Our ref: TR010064/Deadline 3

National Highways
Piccadilly Gate
Store Street
Manchester
M1 2WD
0300 123 5000
05/11/2024

TR010064 - M60/M62/M66 Simister Island Interchange EXAMINATION DEADLINE 3 SUBMISSIONS

-DR- Z -0002

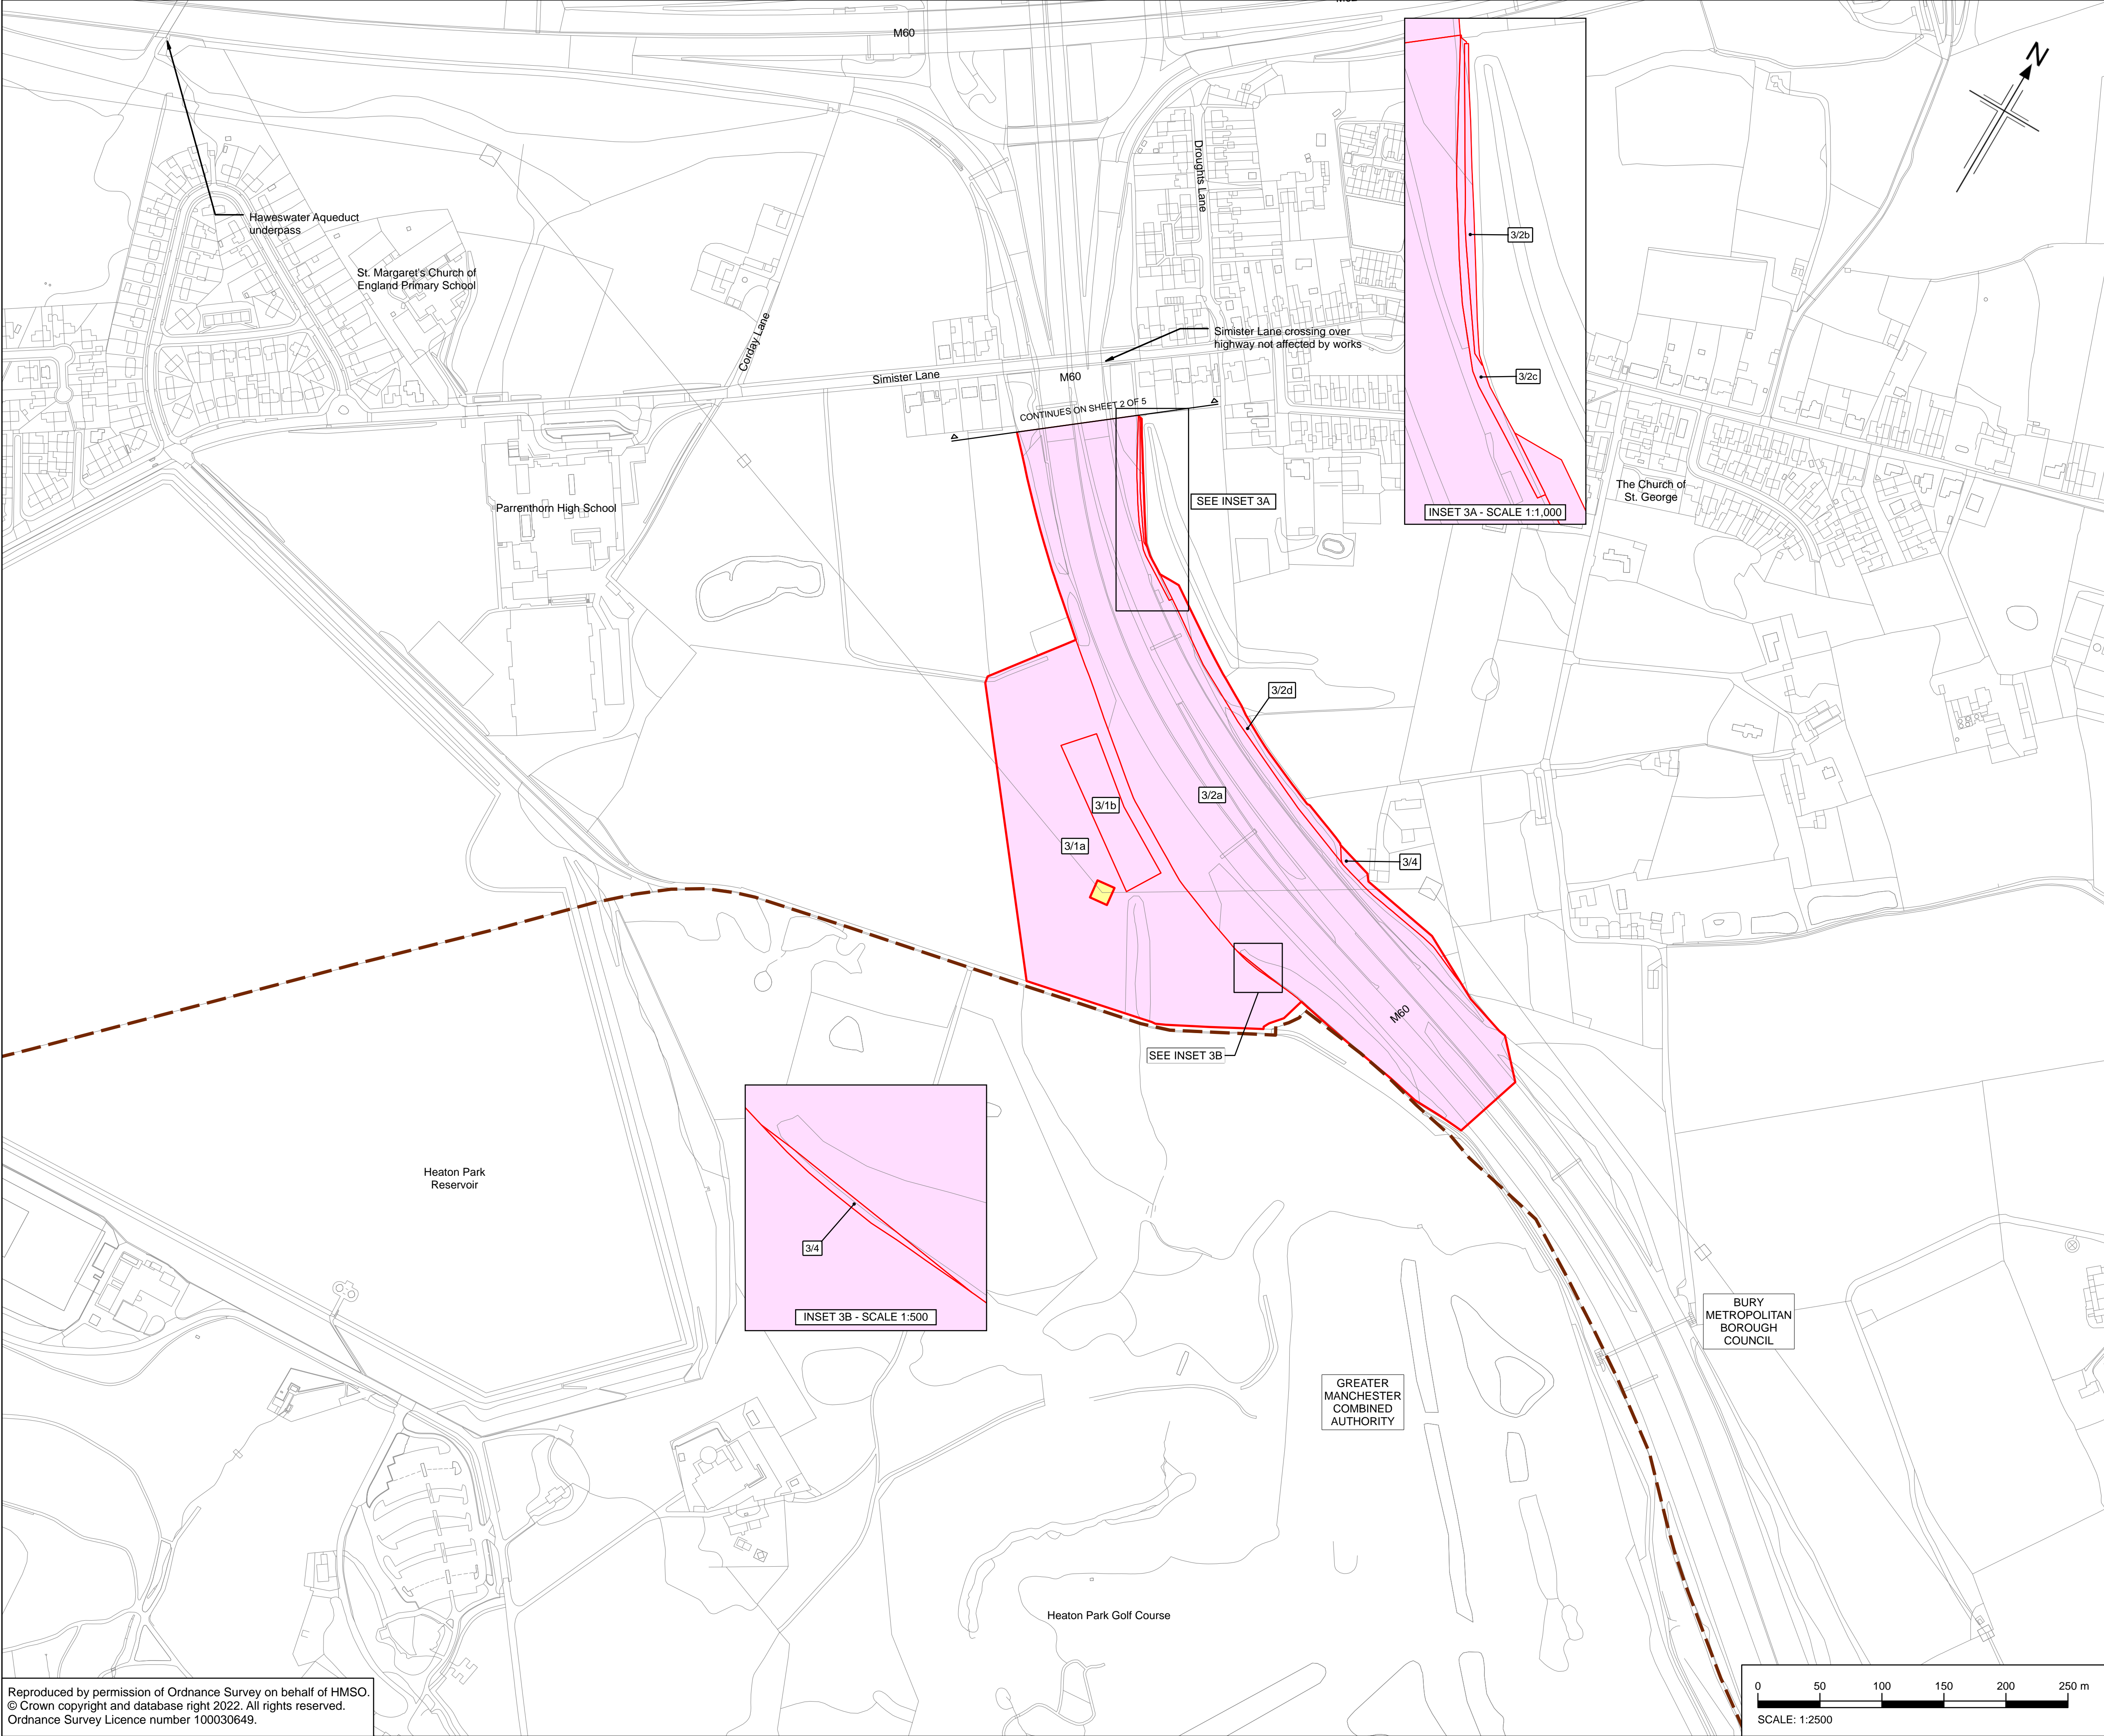
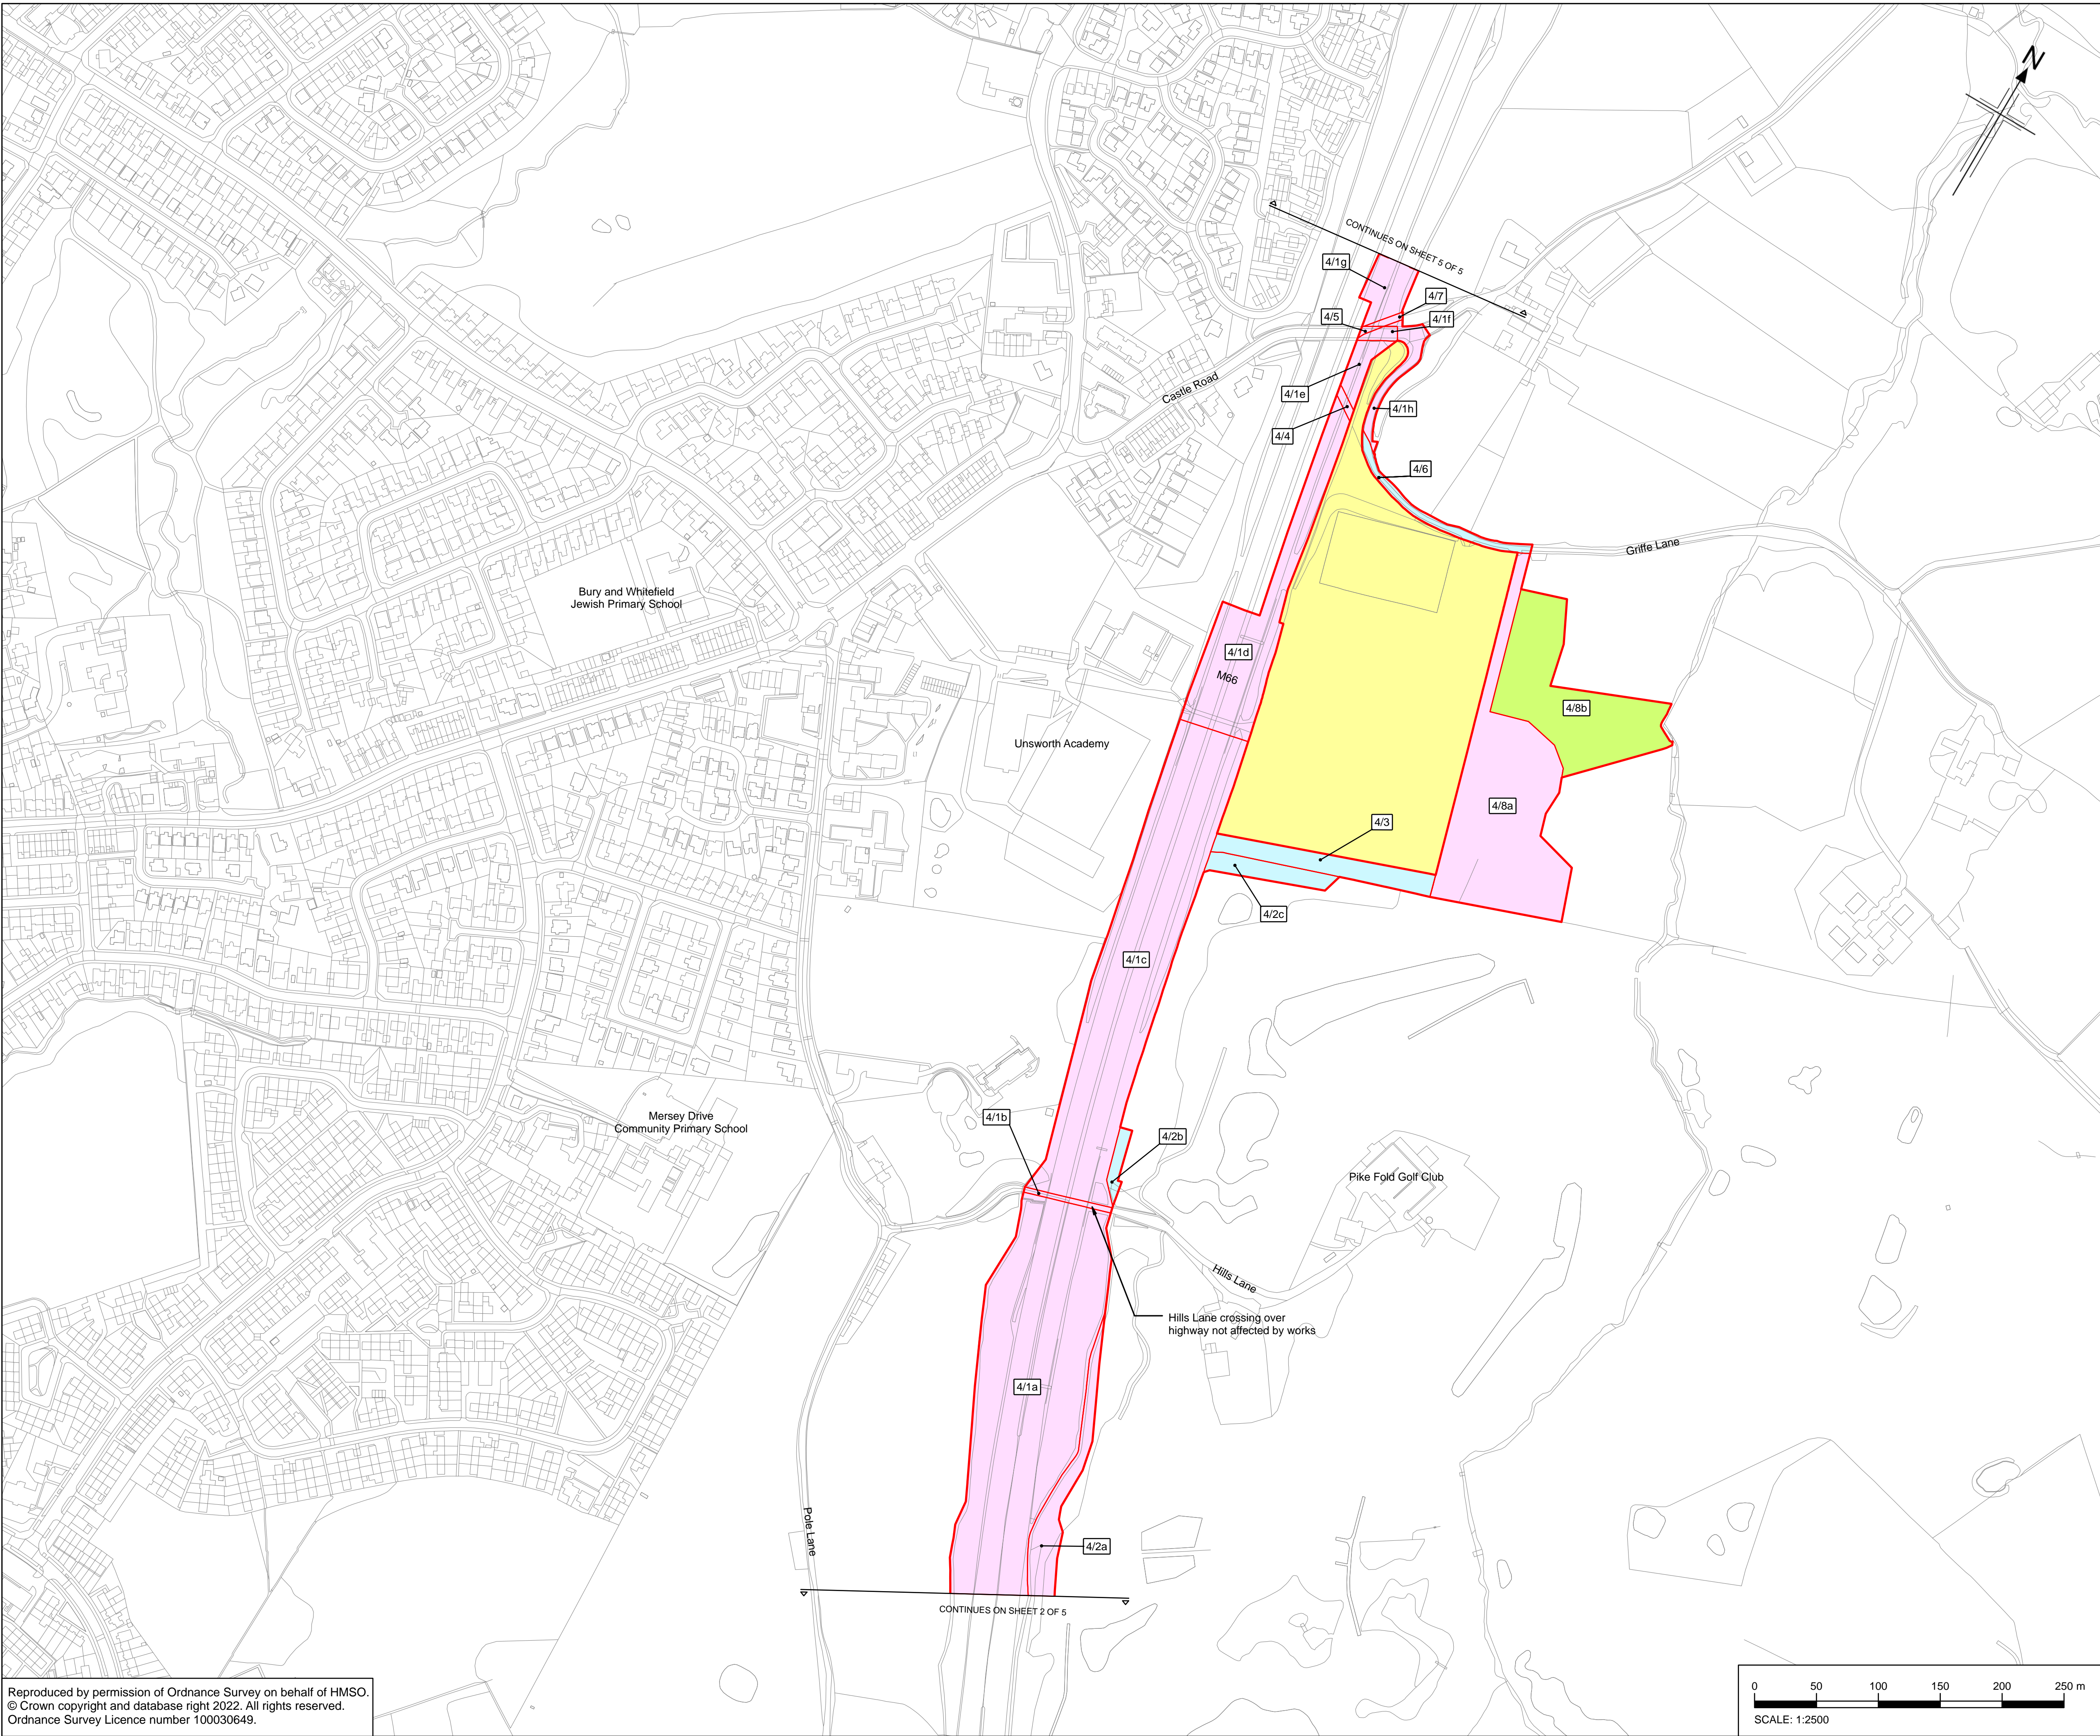
In response to ExA question *CA.1.4* revised Lands Plans [AS-005] has been provided to correctly label Plot 3/3. A further correction was identified and made to move the references for plot 2/1ax into Insets 2G and 2H.
